From: Paul Cann <Paul.Cann@arun.gov.uk>
Sent: 23 June 2021 16:37
To: Planning.Responses <Planning.Responses@arun.gov.uk>
Subject: RE: Planning Consultation on: F/7/21/PL

Engineers comments in respect to surface water drainage;

Application No: F/7/21/PL

Description of Works: Building a new 1.28 Ha high-tech glasshouse, reservoir and parking area adjacent to the existing 6 Ha glasshouse, reservoir and nursery area. This site is in CIL Zone 3 (Zero Rated) as other development.

CLIENT	DPS Limited				
PROJECT	Wicks Farm - East, Ford Lane				
TITLE	Site Layout - Proposed Drainage And Levels				
DRAWN	A Davies		DATE	Feb 2022	
ENGINEER	S Magowan		CHECKED	SRM	
SCALE	1:500 @ A1, 1:1000 @ A3				
			PROJECT NO.	23482	
			DRG. No.	101	REV. B

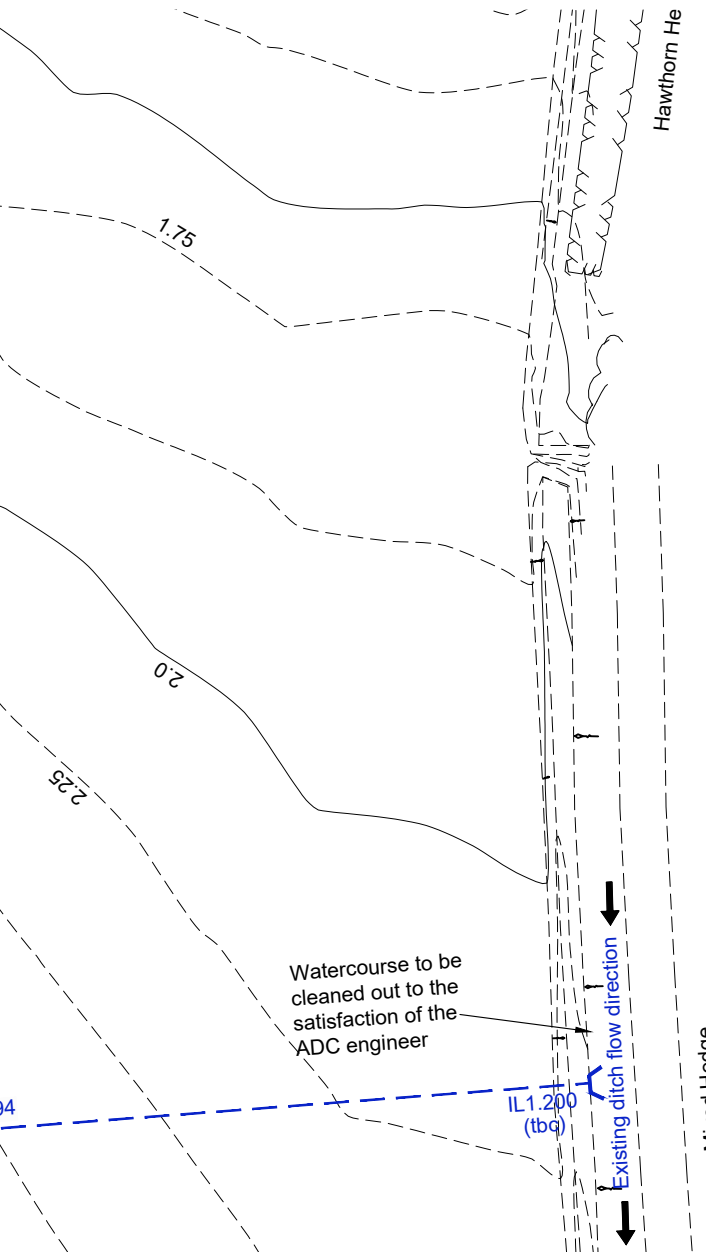
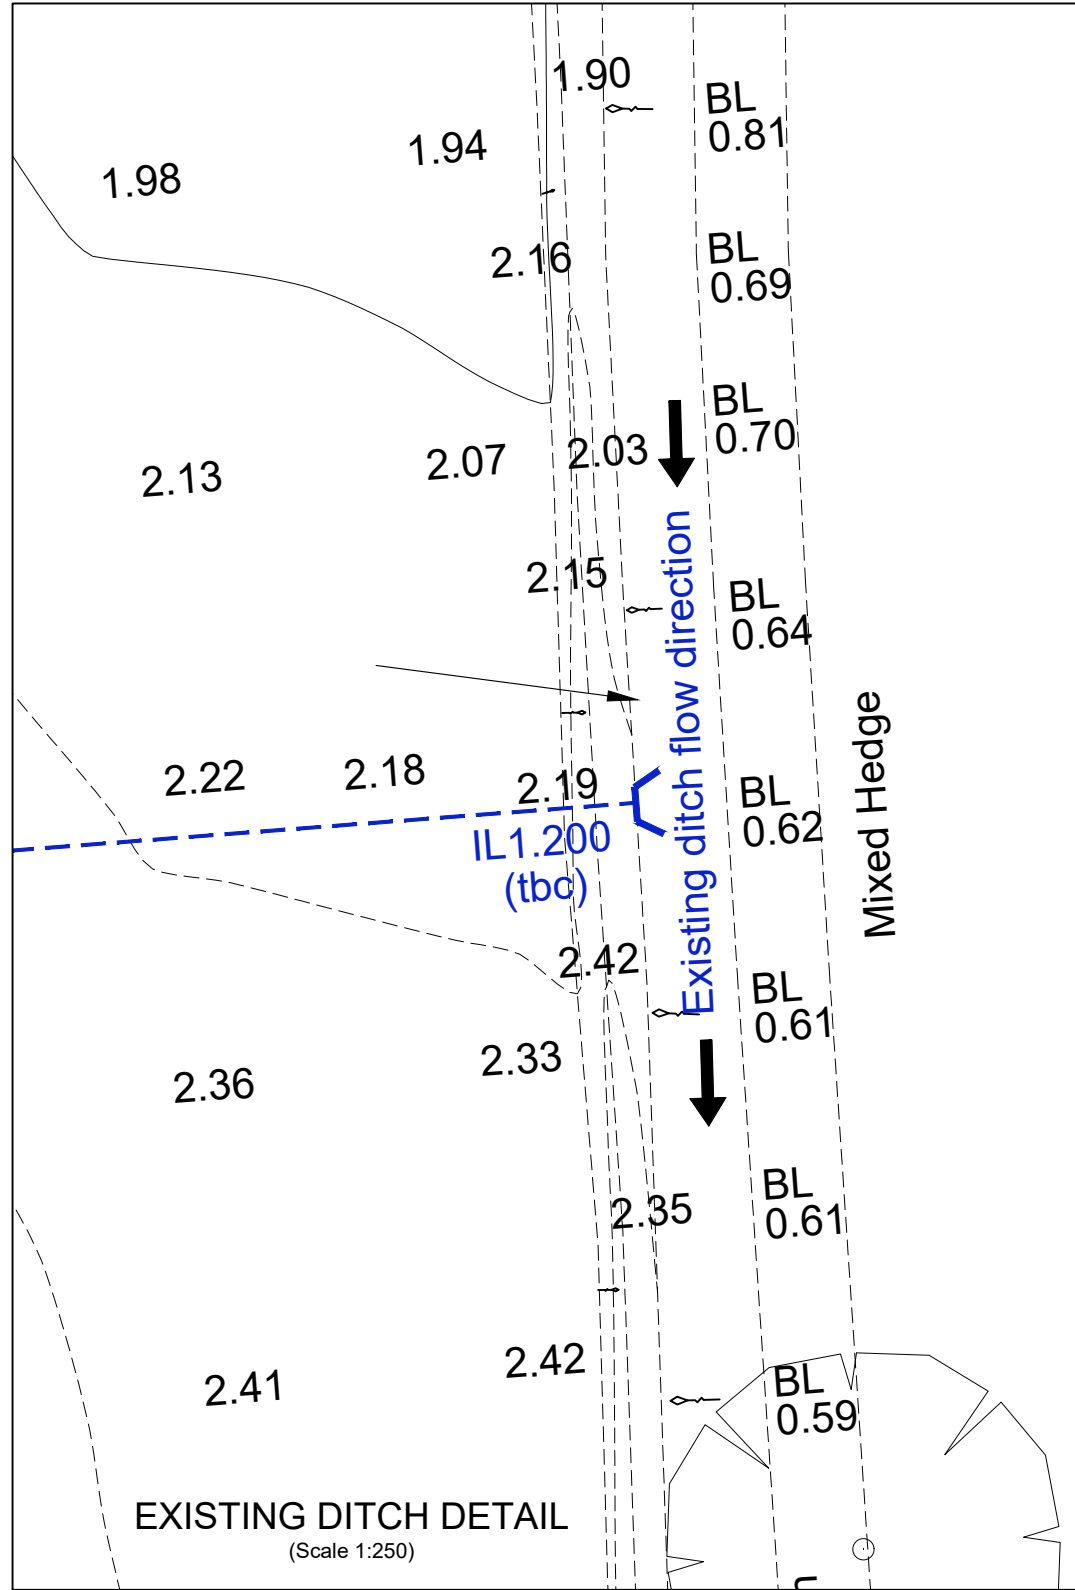
Since part of the development is located with flood zone 2 and 3, the Environment Agency should be consulted on the proposals, including the possible need for flood plain compensation works.

It is appreciated that infiltration potential will be minimal as identified on the neighbouring development to the west, however, any infiltration potential should be utilised where possible.

“Development shall not commence, other than works of site survey and investigation, until full details of the proposed surface water drainage scheme have been submitted to and approved in writing by the Local Planning Authority. The design should follow the hierarchy of preference for different types of surface water drainage disposal systems as set out in Approved Document H of the Building Regulations, and the recommendations of the SuDS Manual produced by CIRIA. Winter groundwater monitoring to establish highest annual ground water levels and winter Percolation testing to BRE 365, or similar approved, will be required to support the design of any Infiltration drainage. No building / No part of the extended building shall be occupied until the complete surface water drainage system serving the property has been implemented in accordance with the agreed details and the details so agreed shall be maintained in good working order in perpetuity.”
